***MODIFICATION REQUEST:
Wollongong Private Hospital
360-364 Crown Street and 9-11 Urunga
Parade, Wollongong (MP70_0070 MOD 1)***

- Modification to the built form, internal layout, service vehicle access and basement car parking of Wollongong Private Hospital

Director-General's
Environmental Assessment Report
Section 75W of the
Environmental Planning and Assessment Act
1979

November 2013

HOSPITAL LOGO SIGNAGE - WEST ELEVATIONS

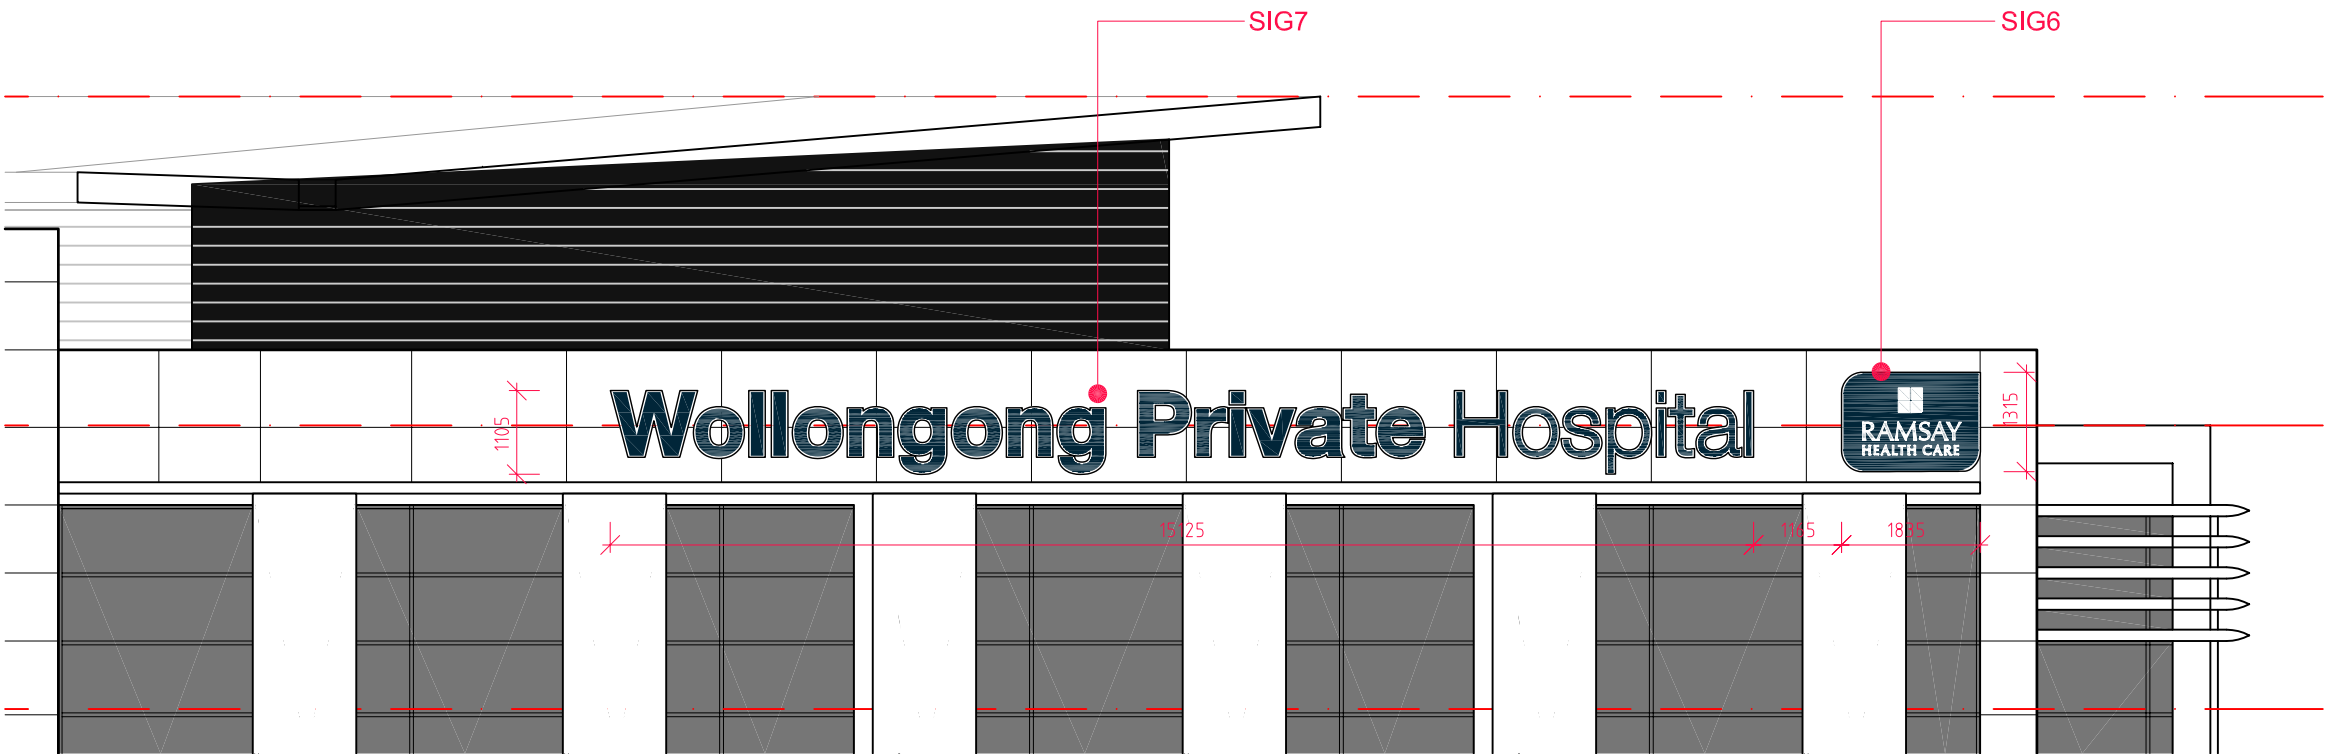
- due to the excessive number of signs, their size and design, it is recommended that the size of all the proposed signage be reduced by 50 per cent and all content be consistent;

As exhibited, originally nine new business identification signs were proposed, though the proponent reduced this number to seven in response to concerns raised by council regarding their potential visual impact and prominence within the local townscape. In addition to removing the larger signs from the Crown Street elevation, the area of the major signage

zones at the top of the western and eastern elevations has been reduced by between 7 sqm and 10 sqm by reducing the scale of each respective sign. The amendments assist in reducing their prominence within the townscape, but maintain the role of communicating WPH within the health precinct.
